Remodelling & extensions
Hascombe 33 Tamarisk Way East Preston

Thank you for your internet representation made on 19th October 2015 which has been recorded as '**an objection**' with the comments as follows:

client	Jason Richardson
job	Hascombe Tamarisk Way East Preston West Sussex
dwg no.	1043.06e
title	Proposed Ground & First Floor Plans
drawn by	SM
checked by	KT
scale	1:100 @ A1
date	05.08.15

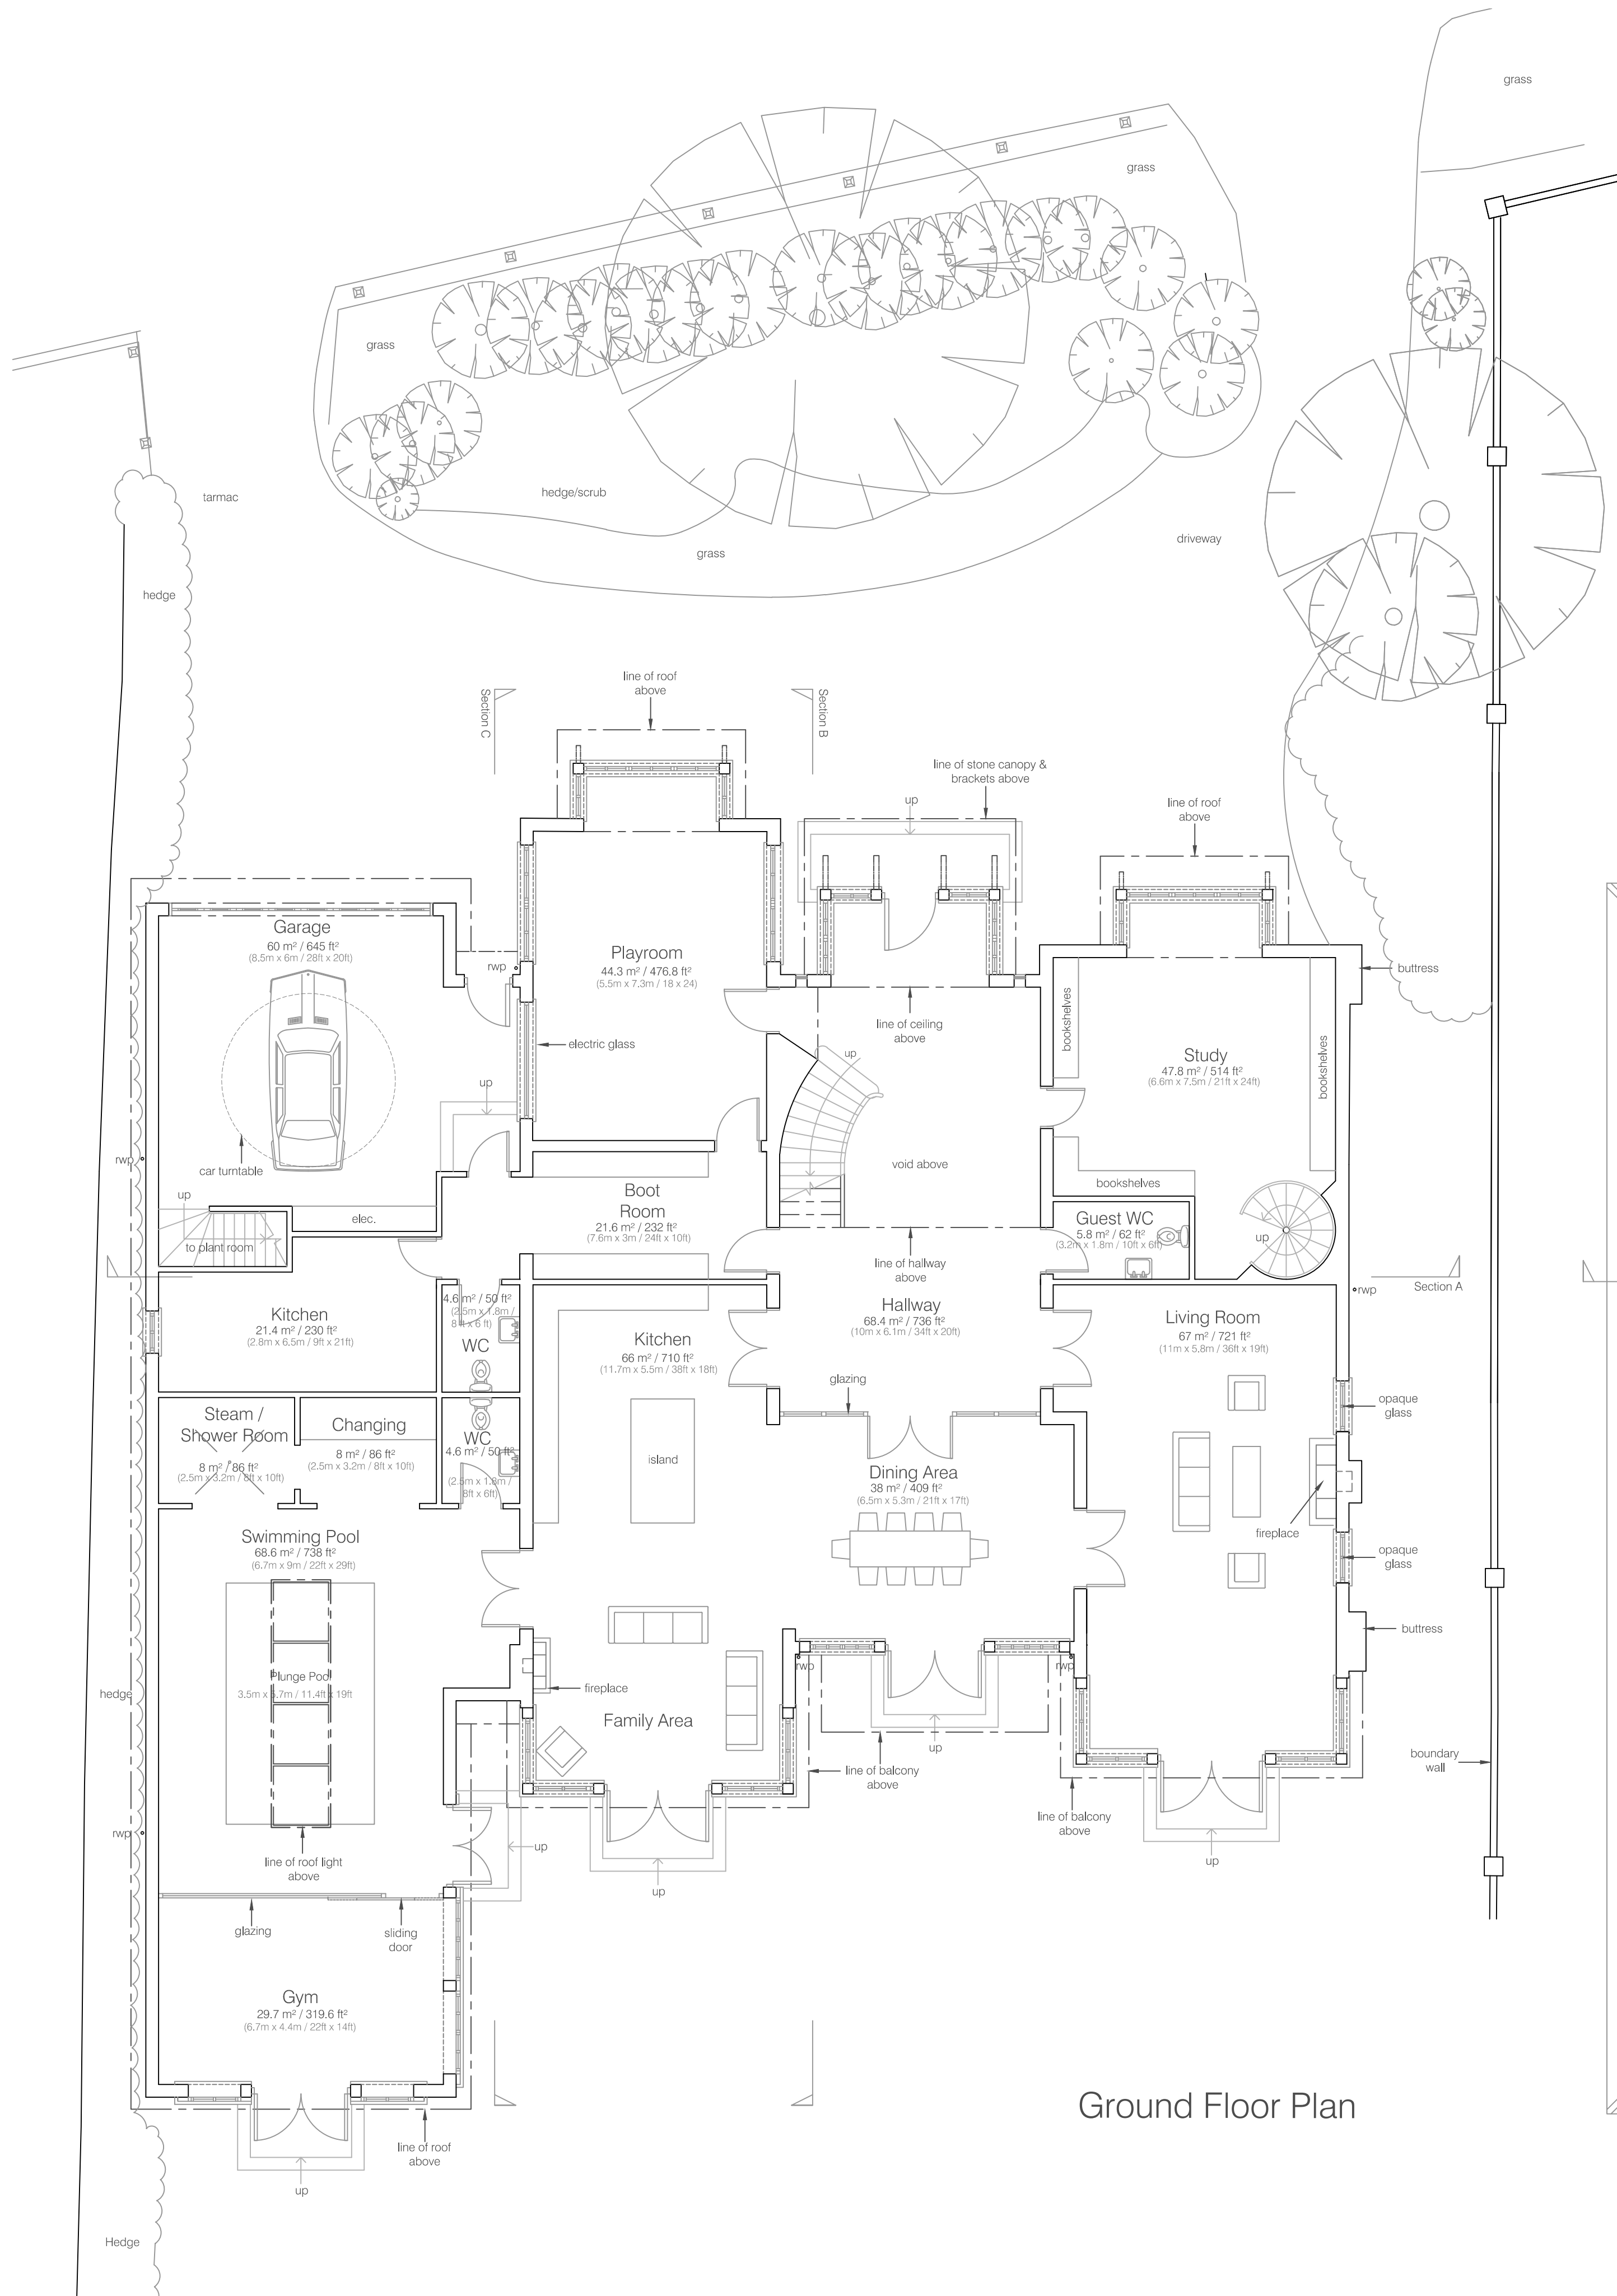
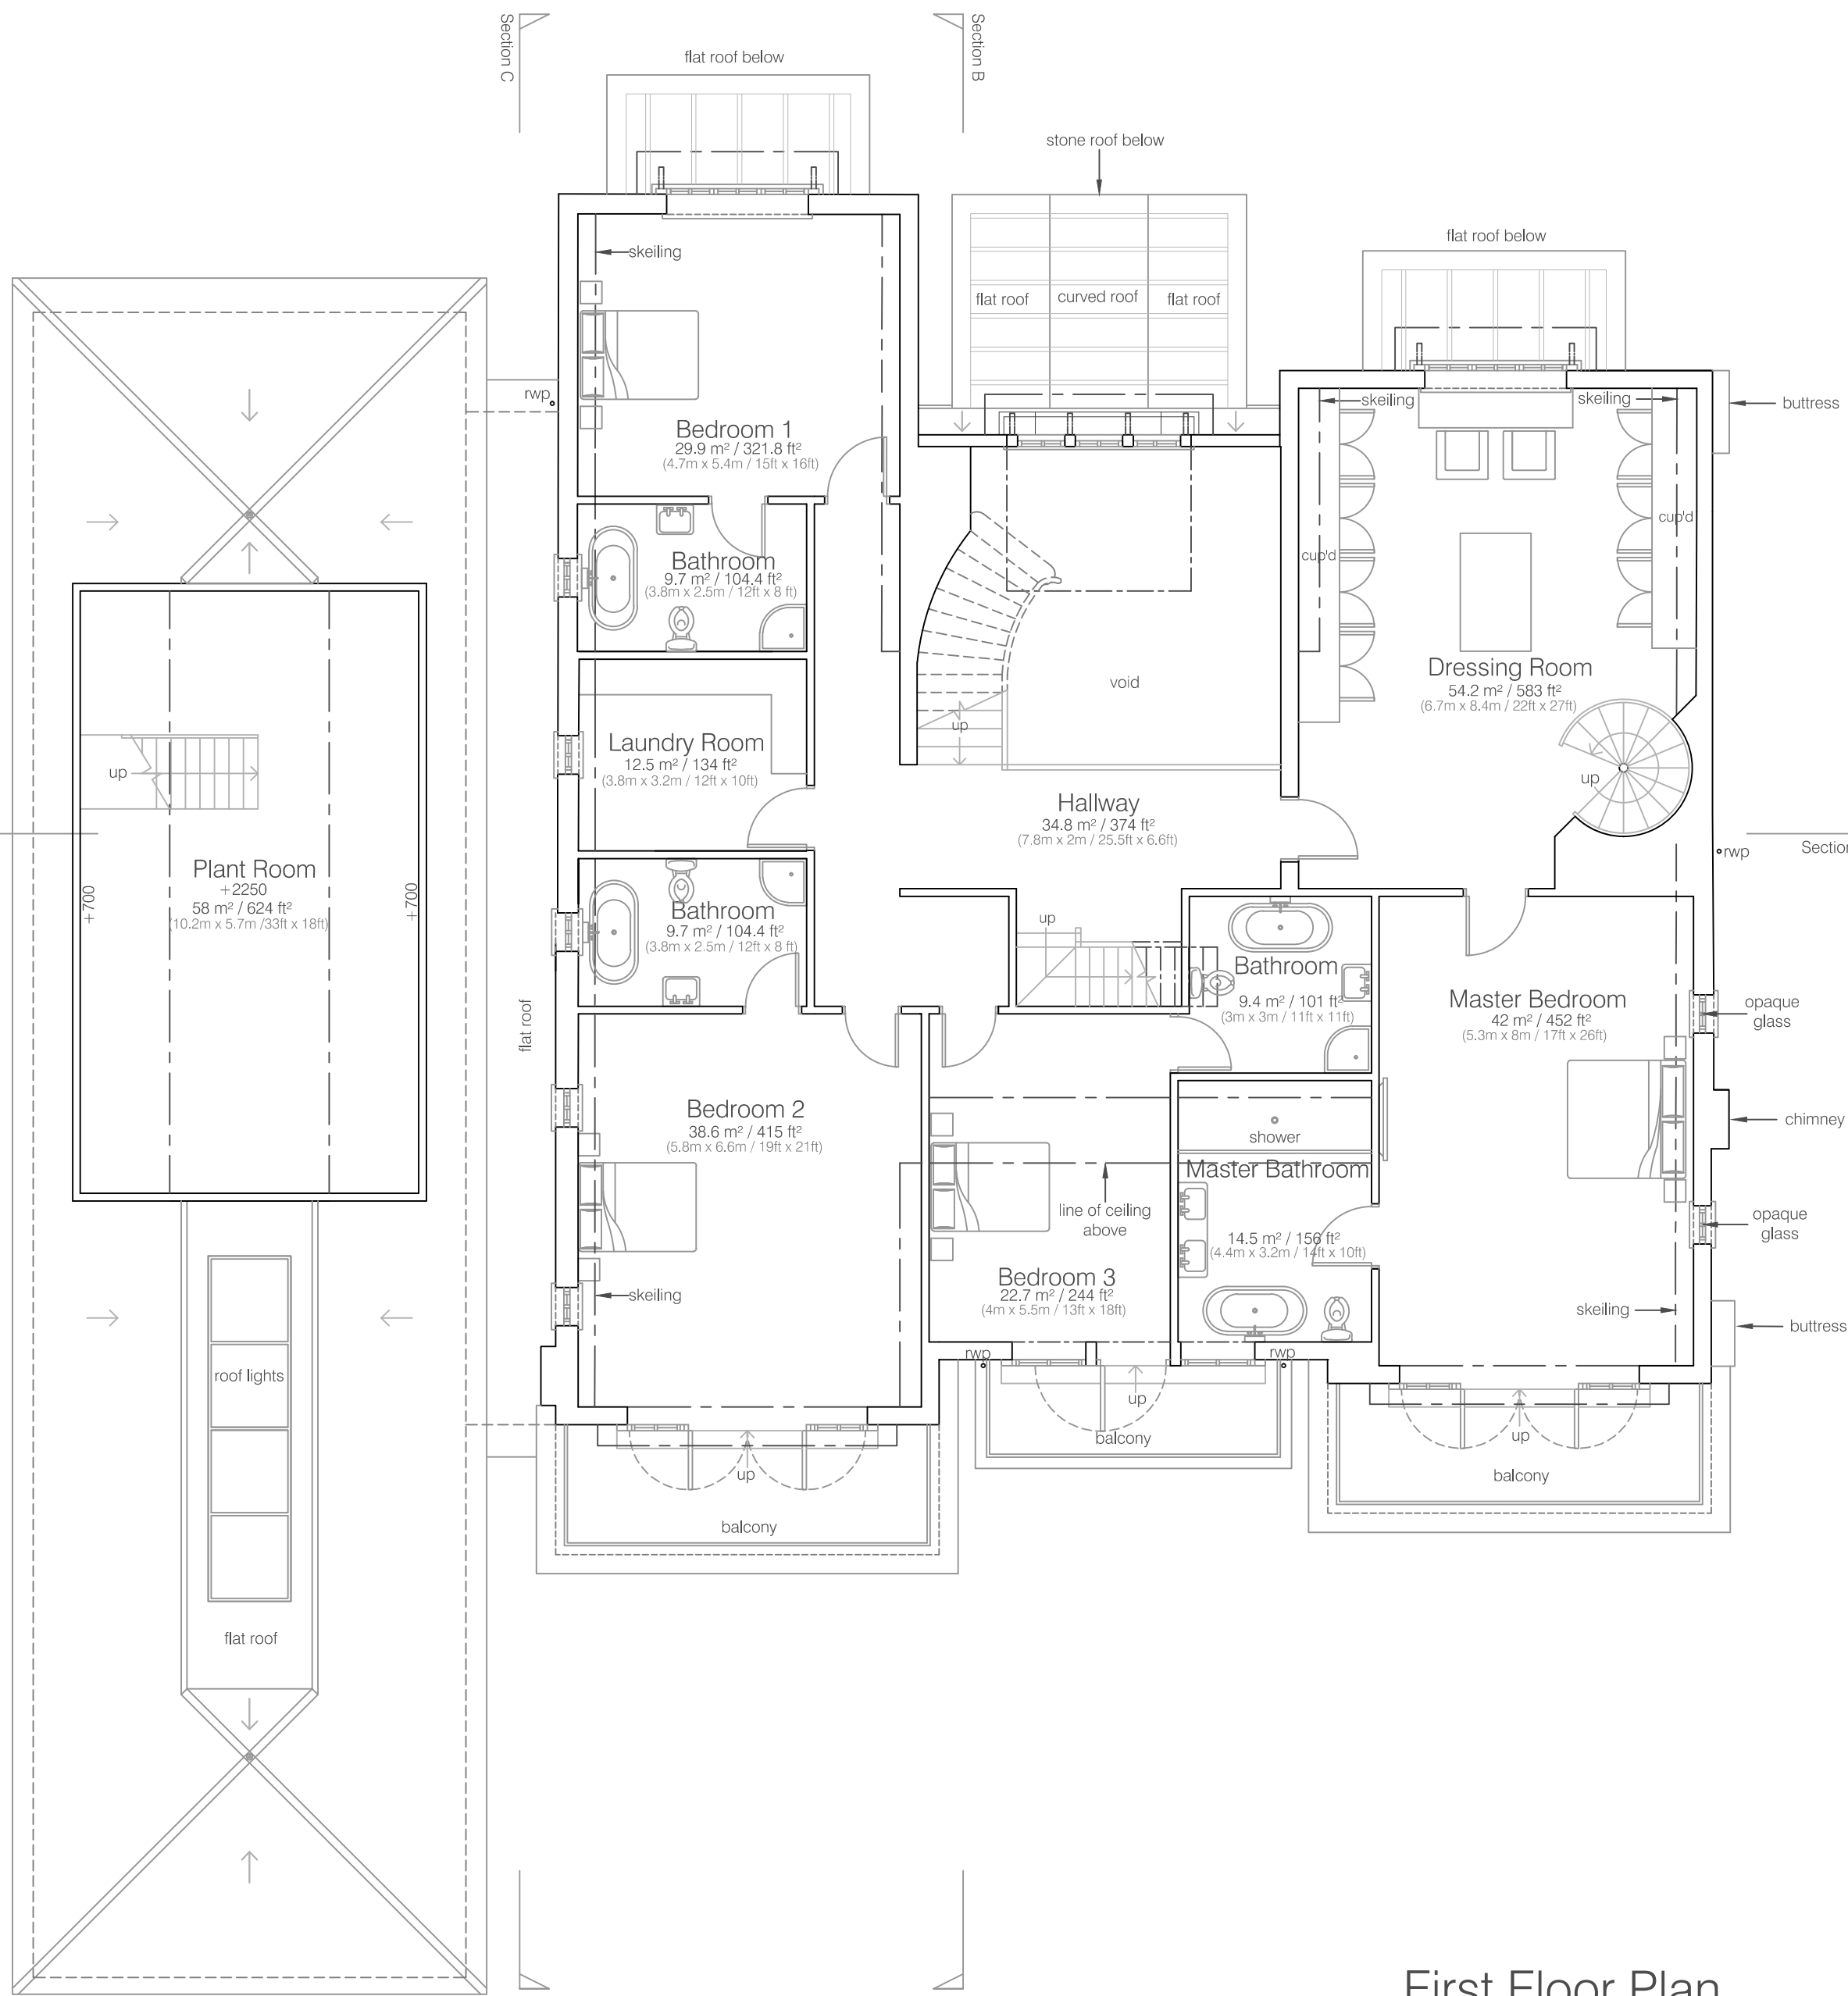
Due consideration needs to be given to the proximity of the development to its eastern boundary and particular the north western corner of the building that seems to abut the boundary line and would obstruct the passage of pedestrians from existing the building this way in the event of a fire.

West Facing Elevation

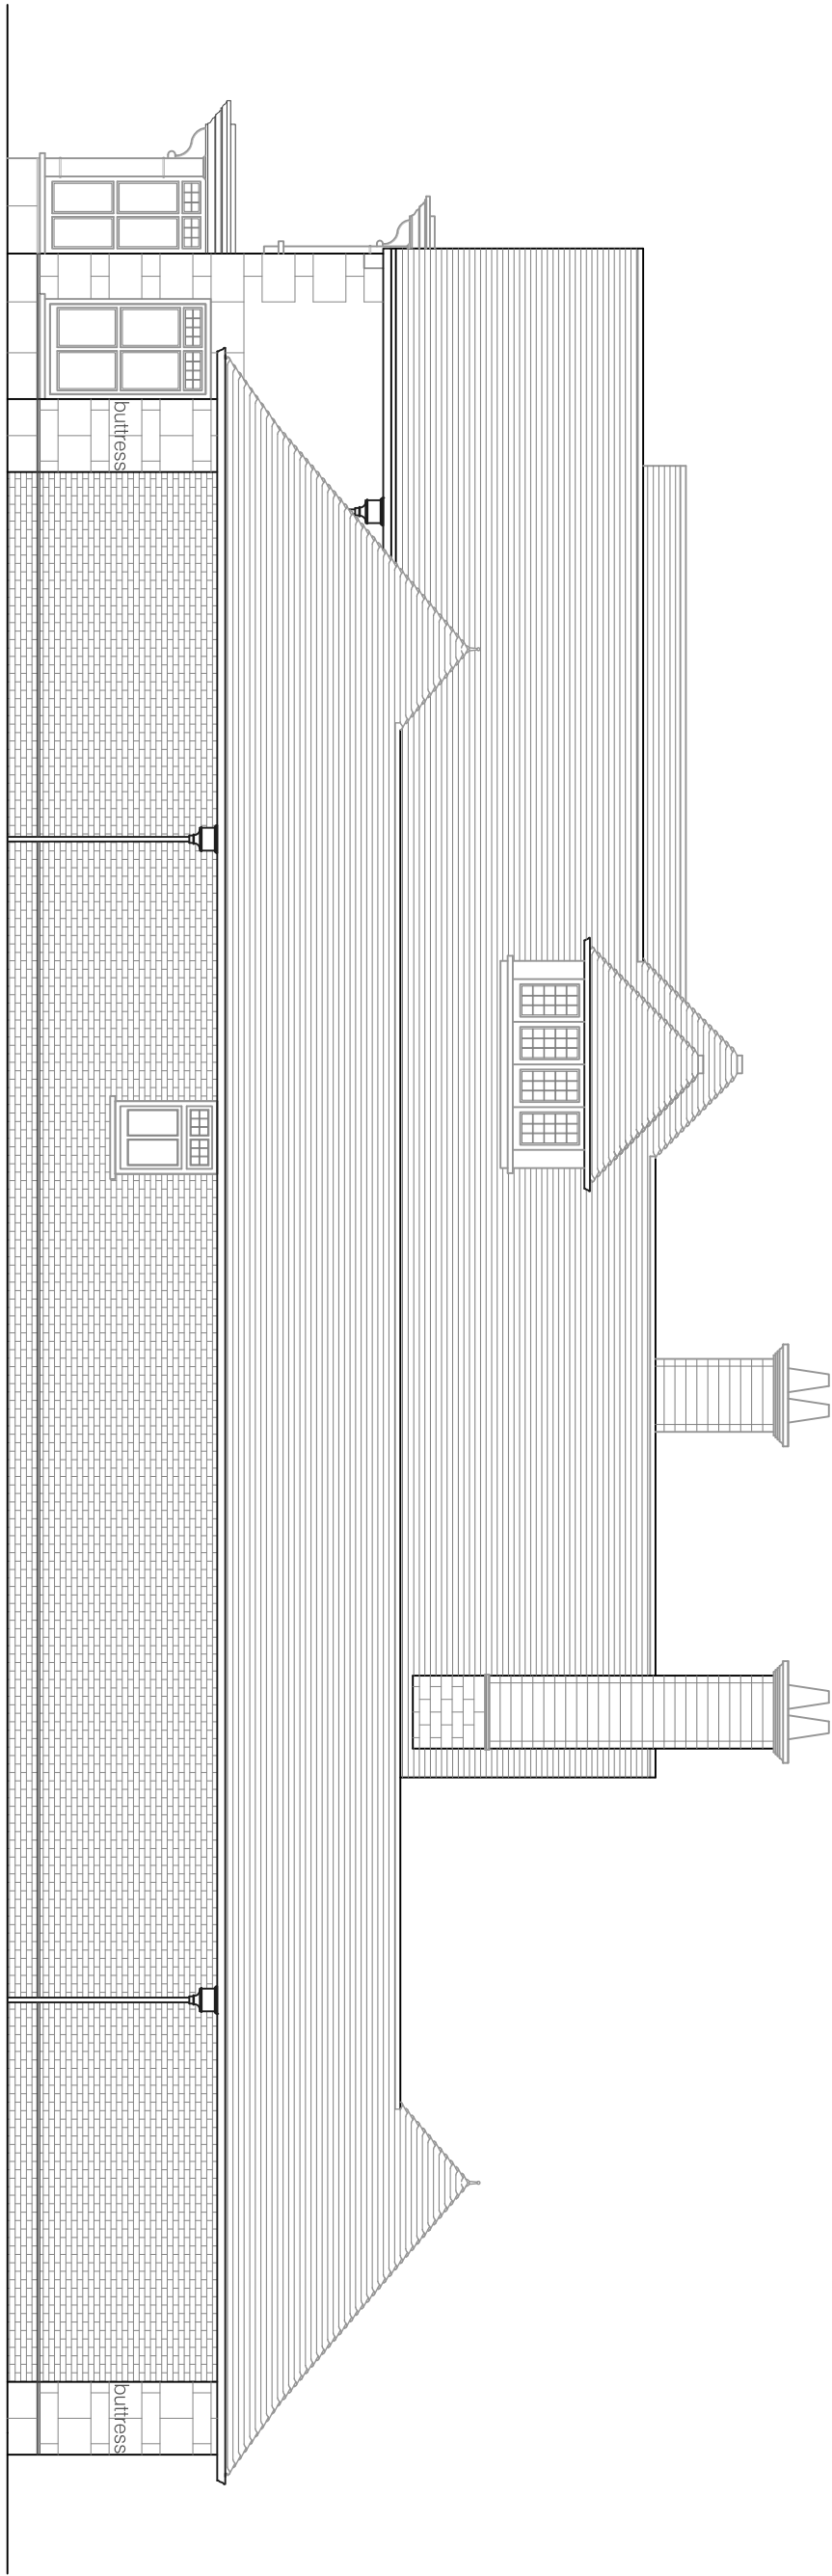
The development will have an adverse effect on the residential amenity of the adjacent occupiers. For instance the window proposed on the west elevation will result in overlooking and a loss of privacy.
